21st May, 2018

Natasha Homsey
Environmental Assessment Officer
Resource & Energy Assessments
NSW Planning & Environment.

I own a beef and cropping farming business on the eastern side, directly next door of the proposed solar farm site.

Orange Grove Road, Gunnedah
1% AEP Flood Depth
Existing Scenario

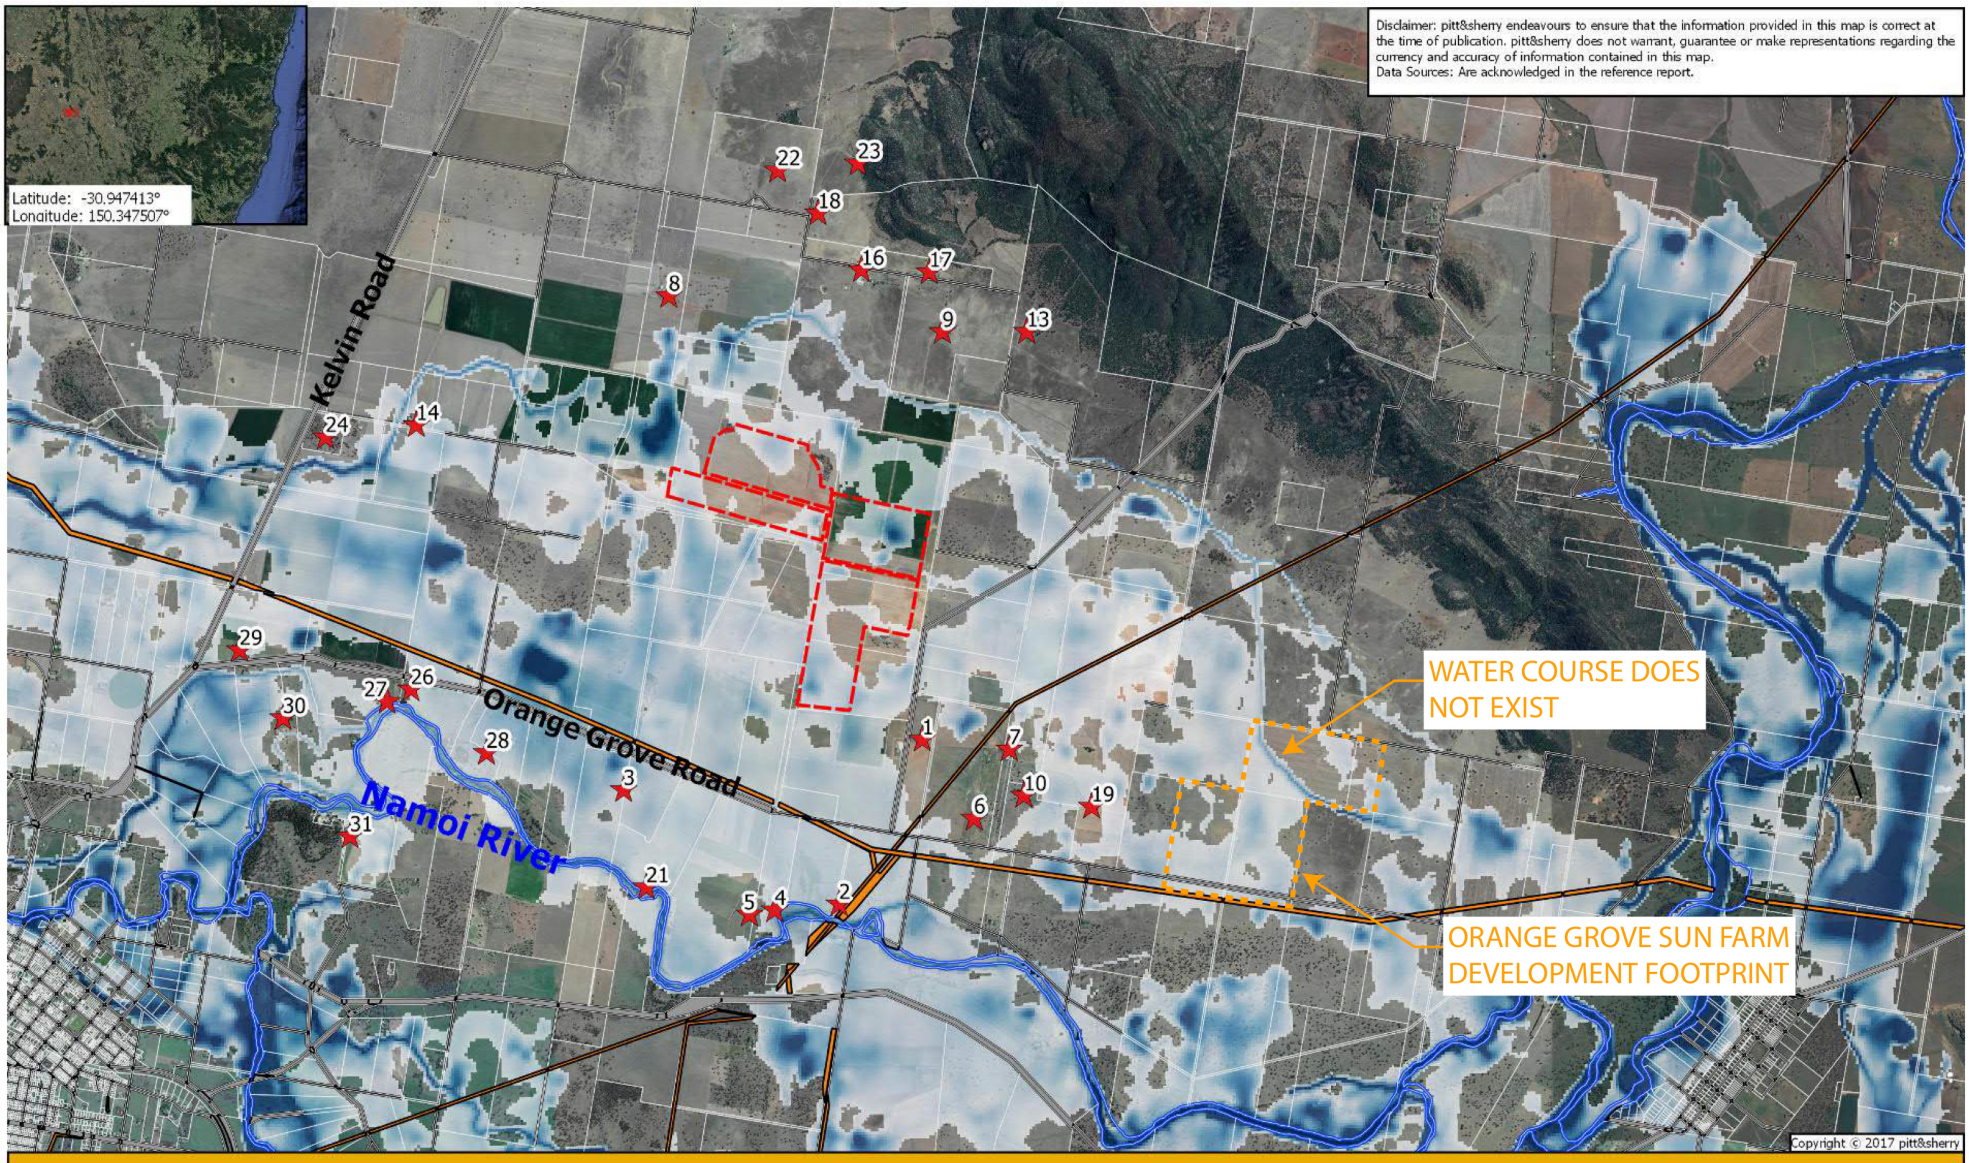
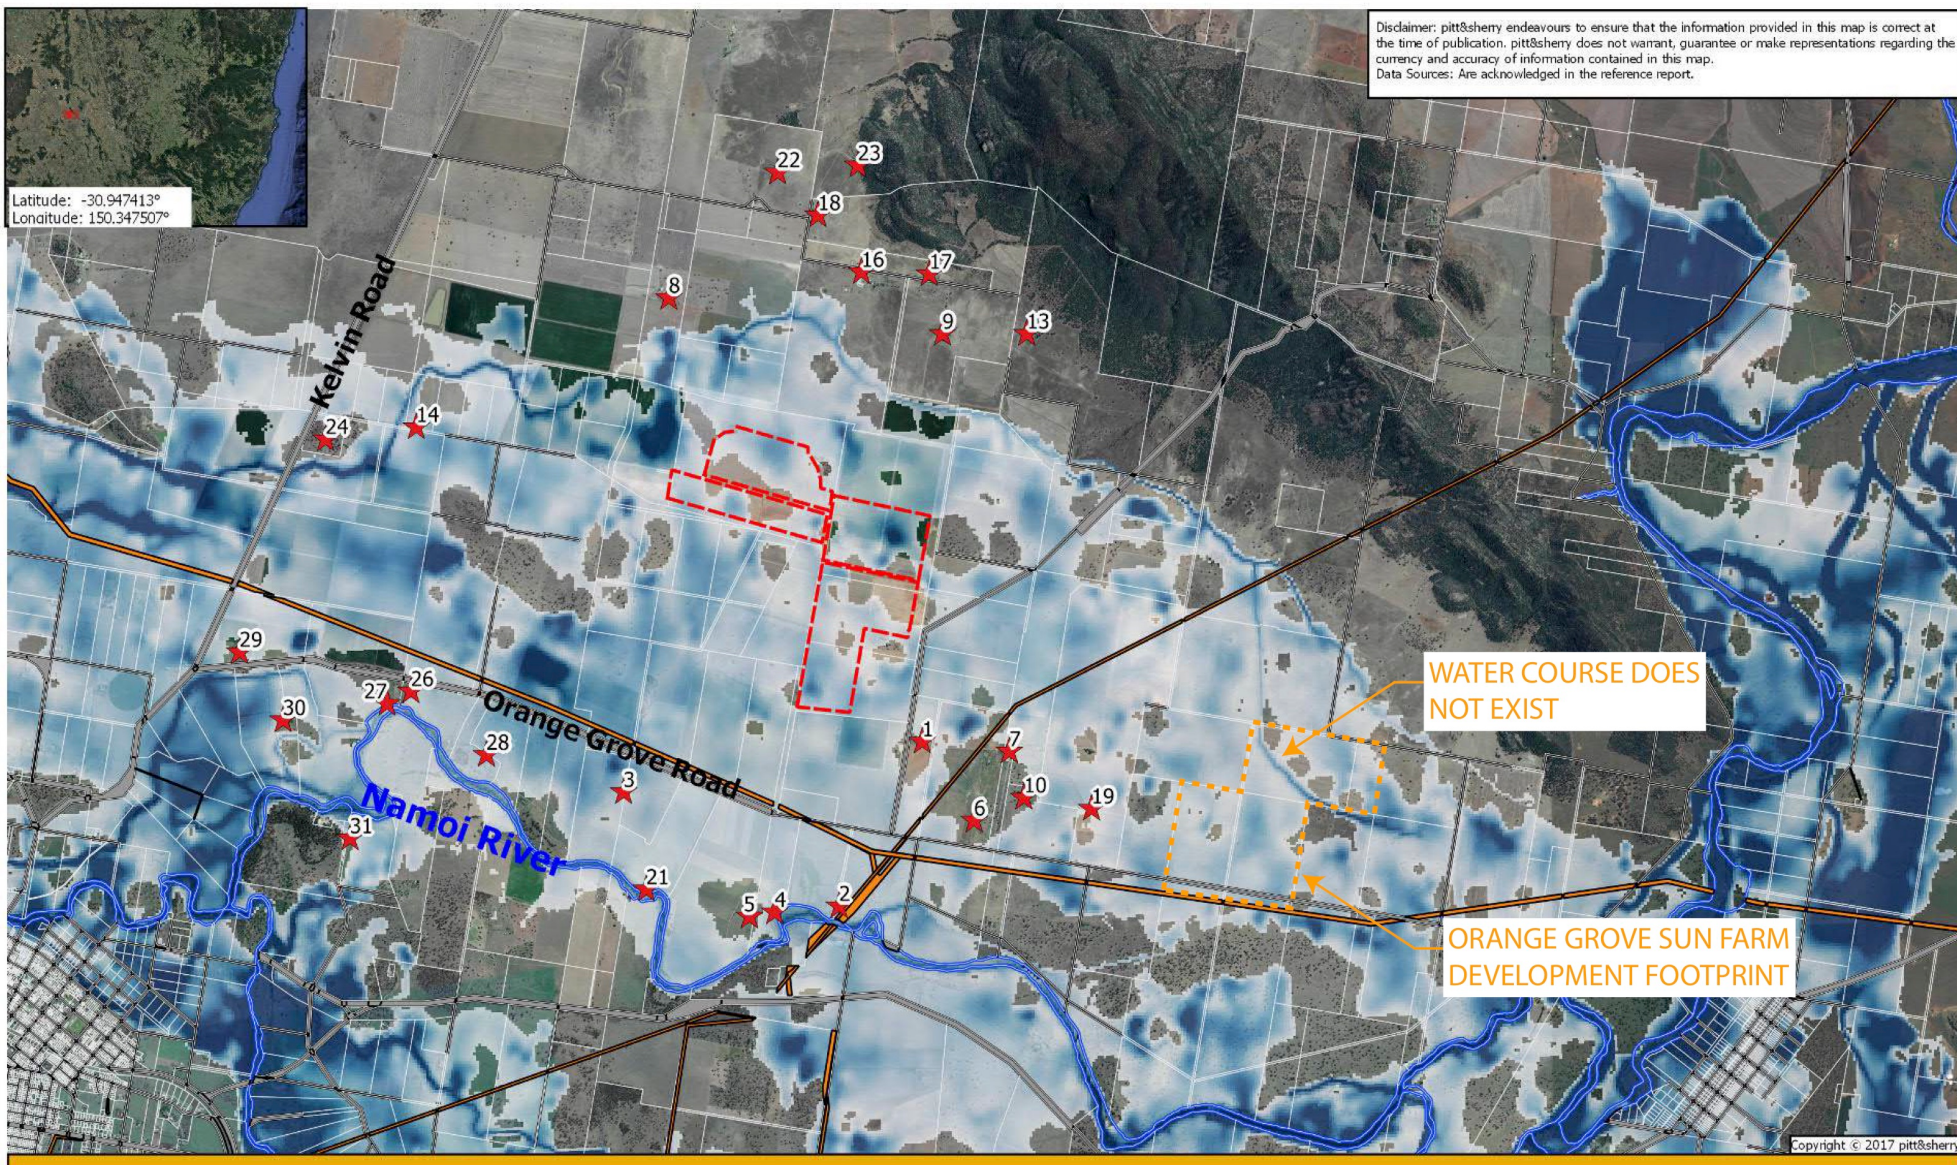
I have lived in our property for 10 years and have seen several episodes of flooding. Unfortunately the maps provided by Photon Energy in the EIS do not appear to be an accurate record of flooding. The maps show areas of land which do not flood when in actual fact these parcels of land have gone under water in recent episodes of flooding.
